Authority	Authority's Reference	Authority Contact	Authority Notification	Submission Due	Submission Made
NSW Planning, Industry & Environment	SSD-29668067	Patrick Copas	7/06/2022	7/07/2022	13/06/2022

Address	Land Title
311 South Street, Marsden Park	Lot 31 DP 262886

Exhibition of Environmental Impact Statement (EIS) for the South Street Warehousing Estate. Construction and operation of a warehouse and distribution estate, comprising: two warehouses; associated office space; a portion of the north-south Collector Road off South Street; and supporting infrastructure, services and landscaping.

Figure 18 Proposed Site Layout Plan

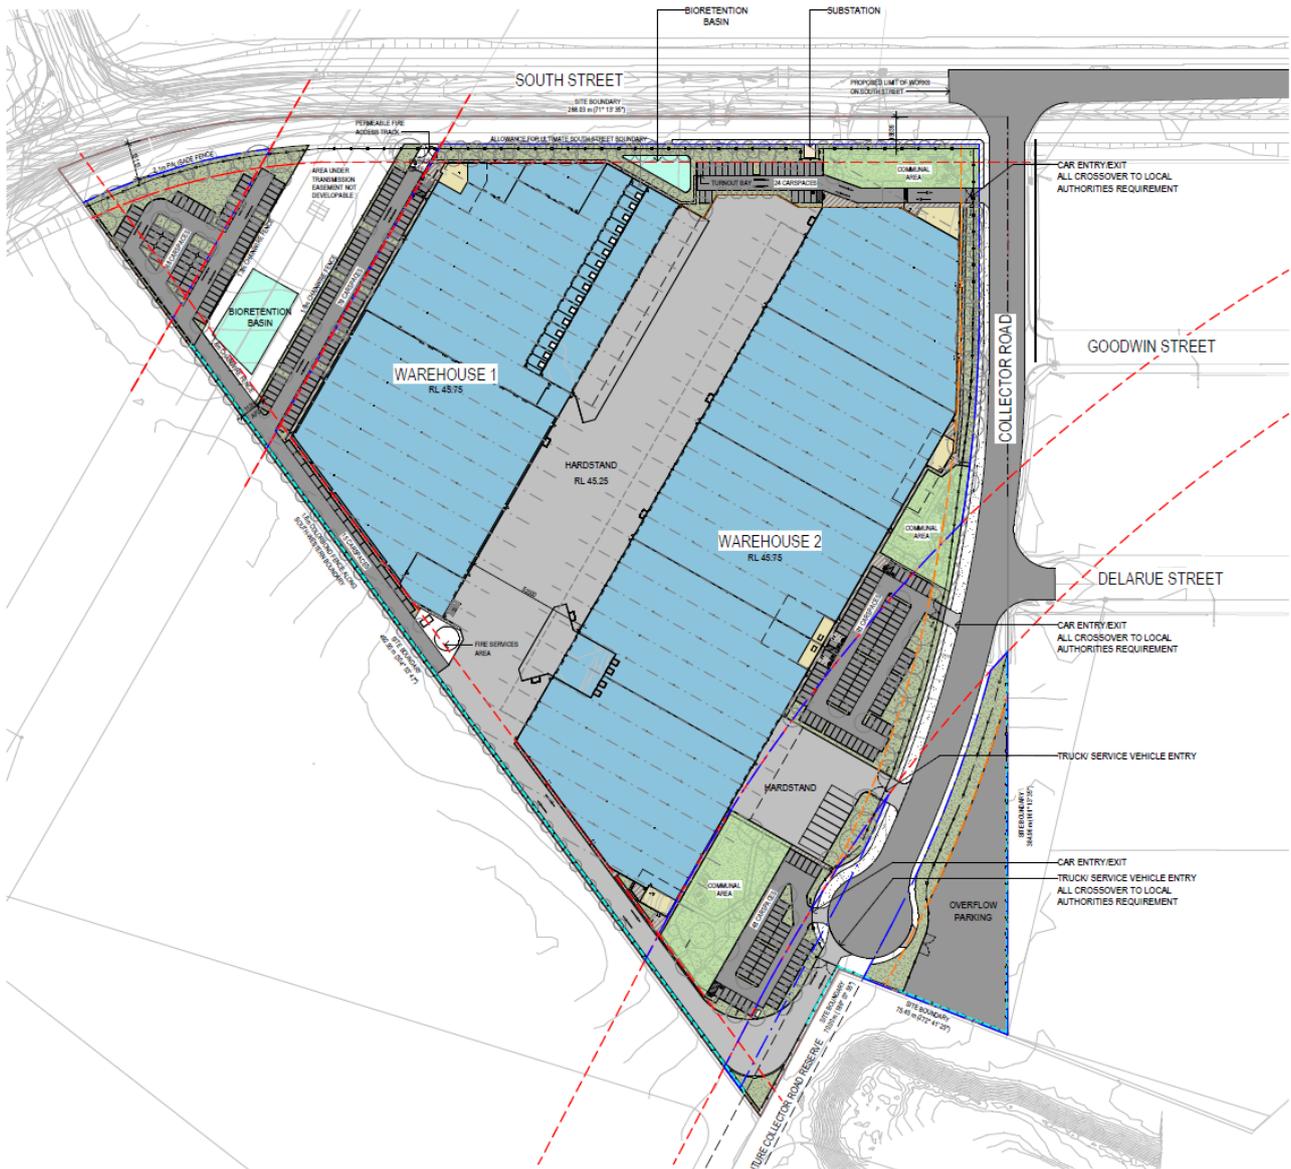
- The applicant will need to complete the application for connection of load process with Endeavour Energy's Customer Network Solutions Branch who are responsible for managing the conditions of supply with the proponent and their Accredited Service Provider (ASP).
- The Architectural Drawings show provision for a substation to the north eastern road frontage.

- Any required padmount substation/s will need to be located within the property (in a suitable and accessible location) and be protected (including any associated cabling) by an easement and associated restrictions benefiting and gifted to Endeavour Energy. Please refer to Endeavour Energy's Mains Design Instruction MDI 0044 'Easements and Property Tenure Rights'.

- Generally it is the Level 3 Accredited Service Provider's (ASP) responsibility (engaged by the developer) to make sure substation location and design complies with Endeavour Energy's standards the suitability of access, safety clearances, fire ratings, flooding etc.

- The planting of large / deep rooted trees to near electricity infrastructure is opposed by Endeavour Energy. Existing trees which are of low ecological significance in proximity of electricity infrastructure should be removed and if necessary replaced by an alternative smaller planting. The landscape designer will need to ensure any planting near electricity infrastructure achieves Endeavour Energy's vegetation management requirements.

- Screening vegetation around a padmount substation should be planted a minimum distance of 800mm plus half of the mature canopy width from the substation easement and have shallow / non-invasive roots. This is to avoid trees growing over the easement as falling branches may damage the cubicle and tree roots the underground cables. All vegetation is to be maintained in such a manner that it will allow unrestricted access by electrical workers to the substation easement all times.
